**RE: Access Logistics Park, 884-928 Mamre Road, Kemps Creek – SSD 17647189
Consolidated Stakeholder Engagement & Response to Submissions**

TABLE 1 RESONSE TO TFNSW COMMEMTS (DATED 23 DECEMBER 2022)	
Agency Comment	Response
Intersection Design and Further Information Request.	
1. TfNSW requires verification that the deceleration and acceleration lanes will satisfy Austroads requirements. TfNSW Road Design team have recommended that the deceleration lane be extended to reflect the expected traffic volumes, articulated vehicle movements, road gradients and speed of travel. An additional shoulder area is also to be provided. In addition, the ultimate arrangement needs to be consistent with the local road network in Mamre Road Precinct Development Control Plan. TfNSW requires the southbound lanes to remain consistent with MRUS2 strategic design, and the deceleration lane to be included within proposed verge and developer owned land.	The LILO design plan has been amended to ensure deceleration lane satisfies Austroads Requirements. As advised, design plan has been amended and an additional shoulder area has been provided (refer to the amended design plan (2021_19_SD_0001_SK0007D Issue

**Annexure 3 – Proposed LILO with TfNSW Ultimate Design Overlay  
2021\_19\_SD\_0001\_SK00018 Issue A**

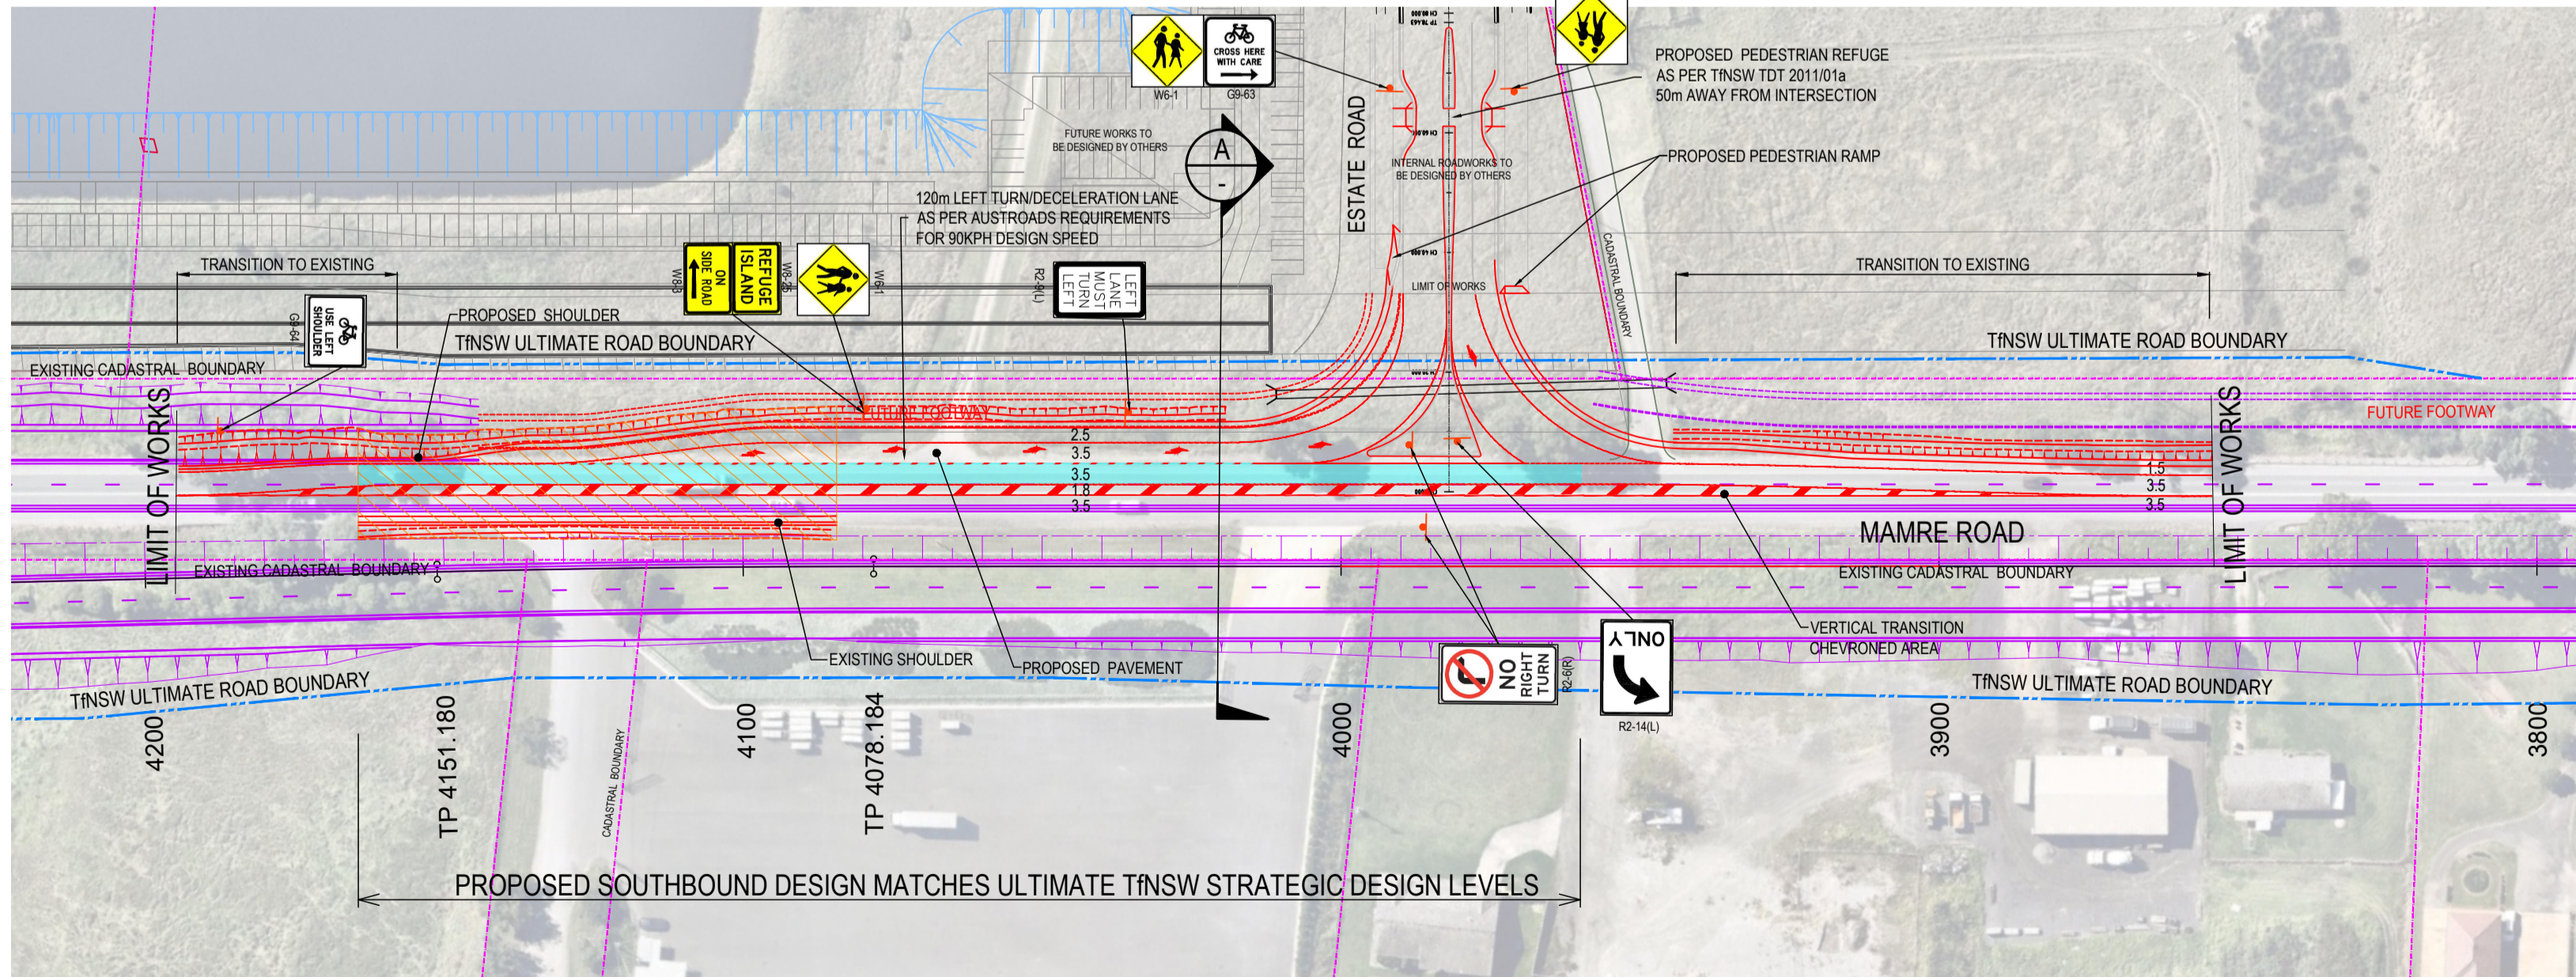
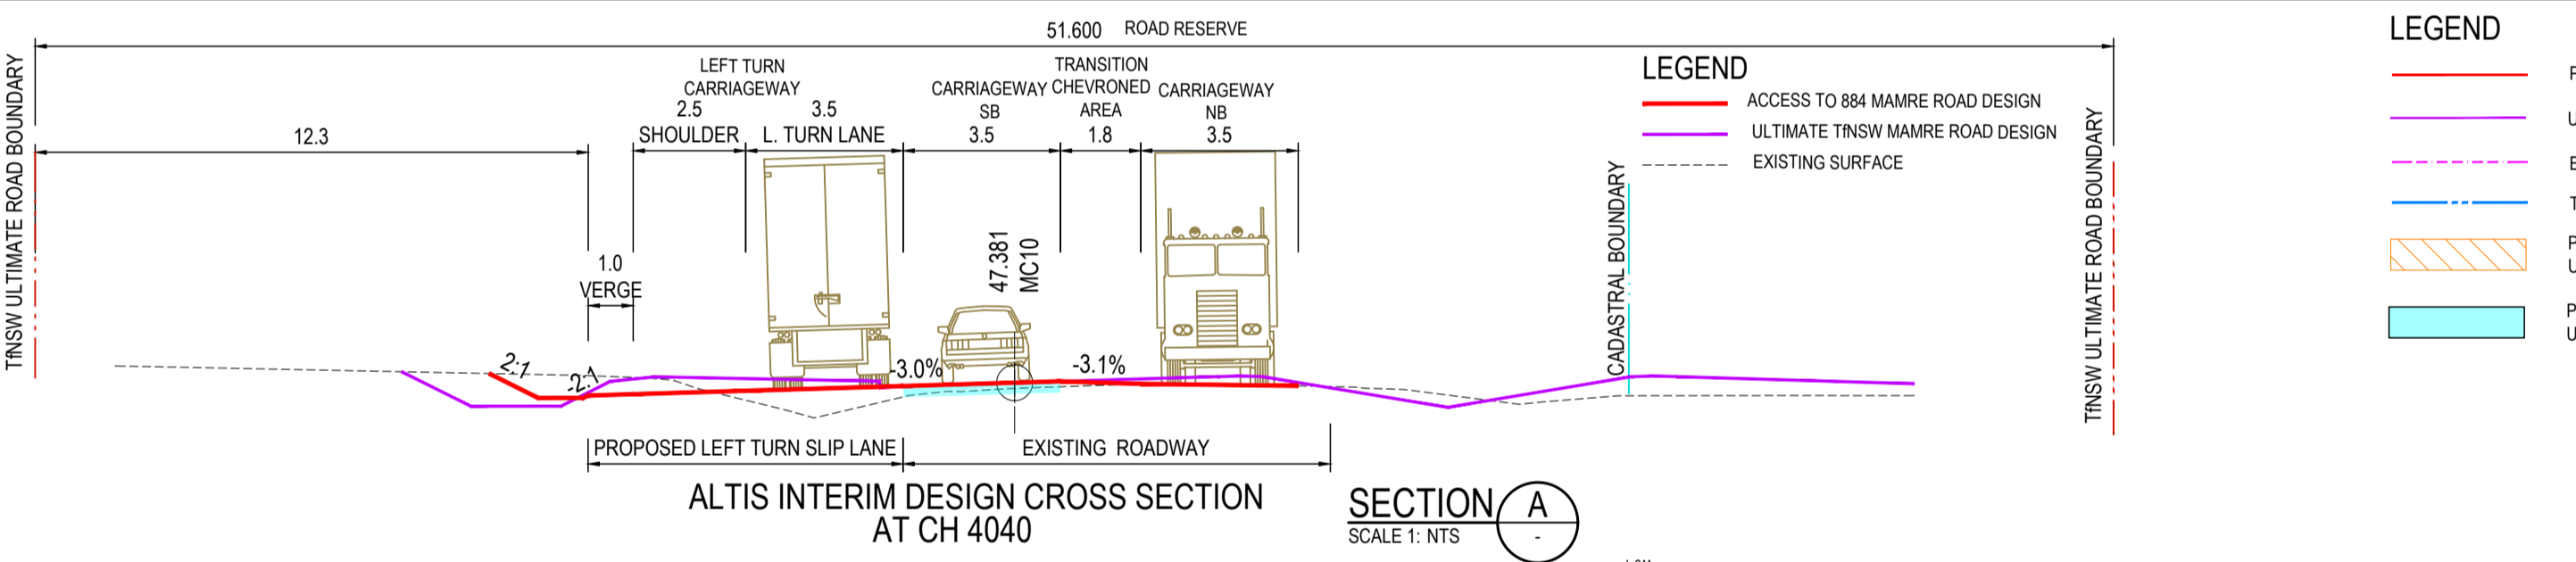
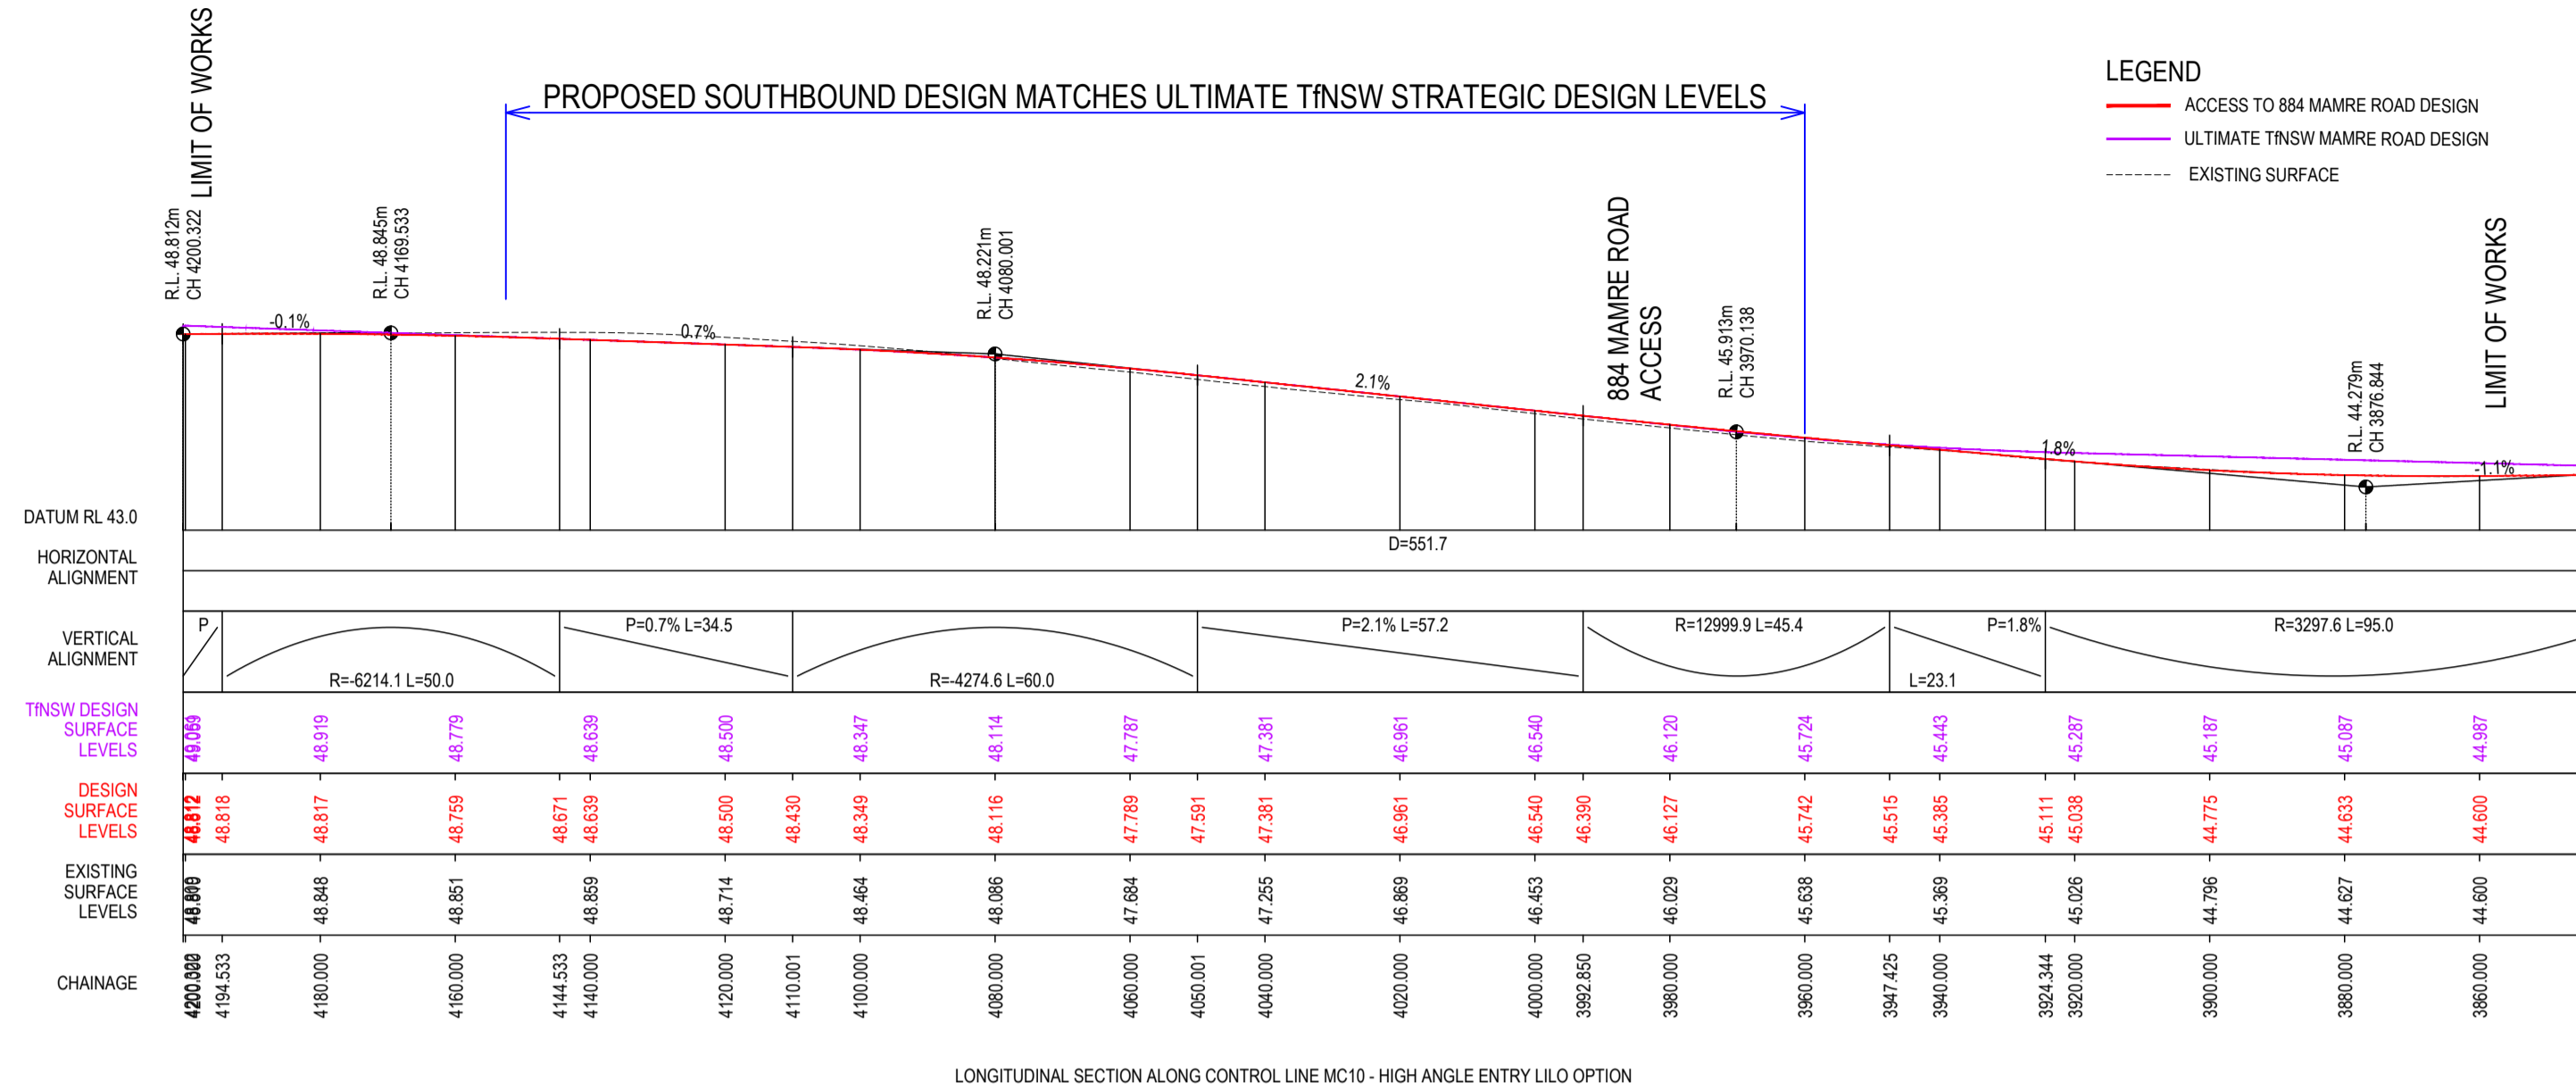
8. Design showing location of LILO with the ultimate Mamre Road upgrade alignment	The strategic design has been overlaid on the TfNSW Mamre Road "Ultimate" design. Refer to Drawing No. 2021_19_SK_0007. The plans show that the LILO is constructed outside the ultimate Mamre Road design footprint and includes a Shared Path that can tie up with the ultimate design following the merger.

APPENDIX B – Strategic Design - Swept Path of PBS Level 3 Type A Vehicle

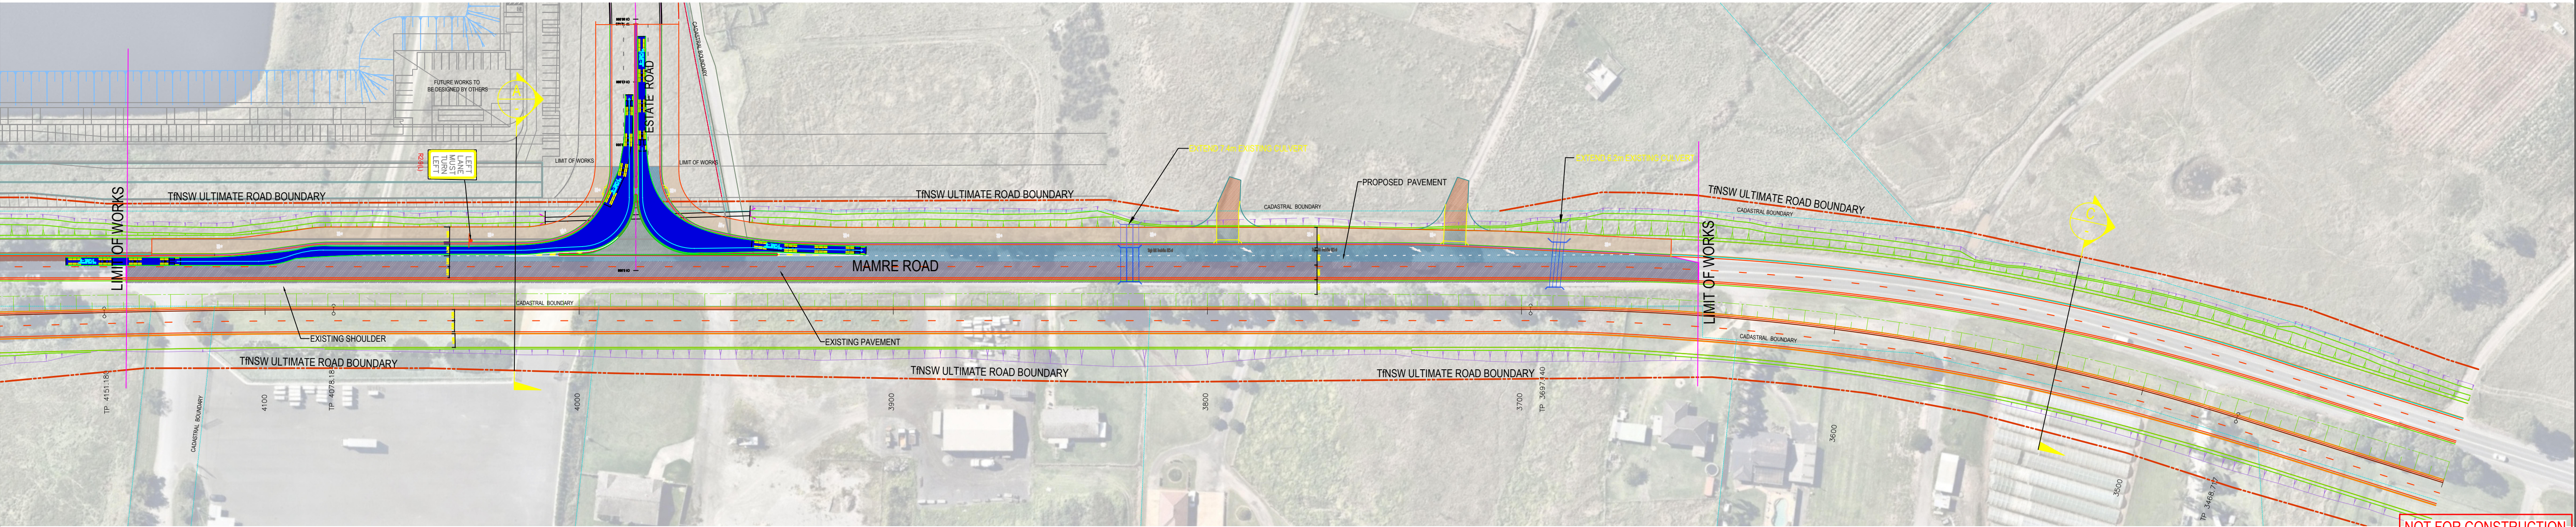
7. Swept paths of the longest vehicles simultaneous entry/exit in line with Austroads Std	36.5m PBS Level 3 Type A vehicle has been adopted as the check vehicle to assess the swept path for simultaneous entry / exit. Swept path analysis is as shown on the plan attached in Appendix B.

APPENDIX C – Strategic Design – LILO Restricting Right Turns at Mamre Road

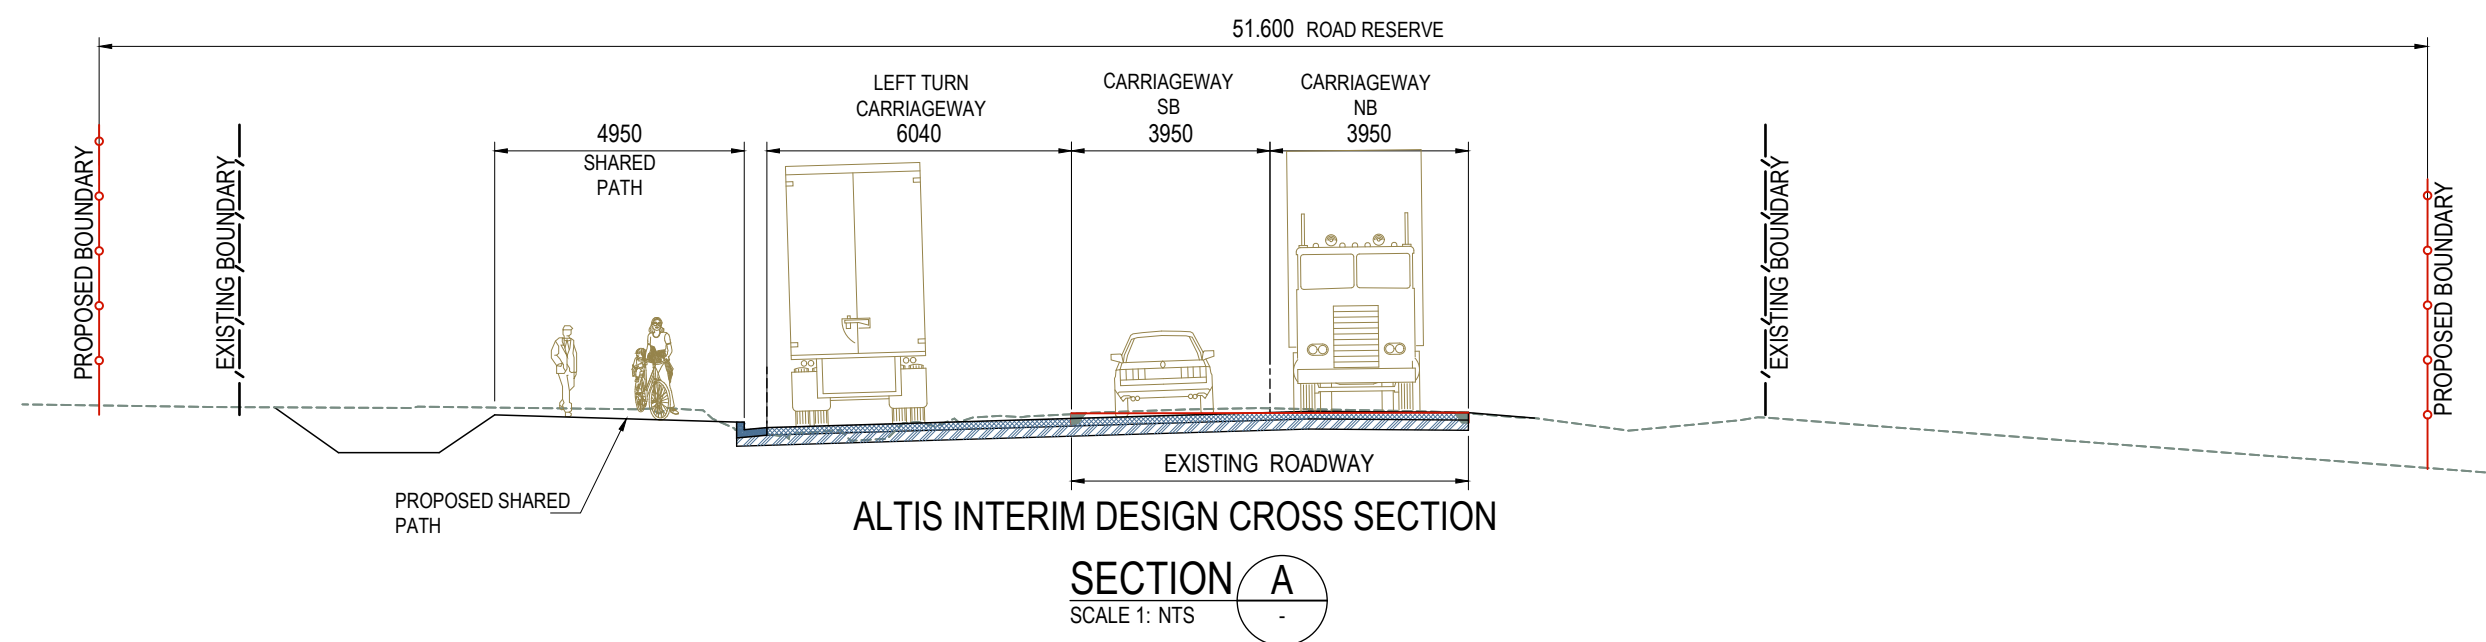
5. LILO is to be designed to physically restrict right turn movements at Mamre Road	The raised concrete median on the design has been extended to physically restrict or make it difficult for a vehicle to perform a right turn movement at Mamre Road. This is supported by the installation of a regulatory sign R2-6(R) No Right Turn
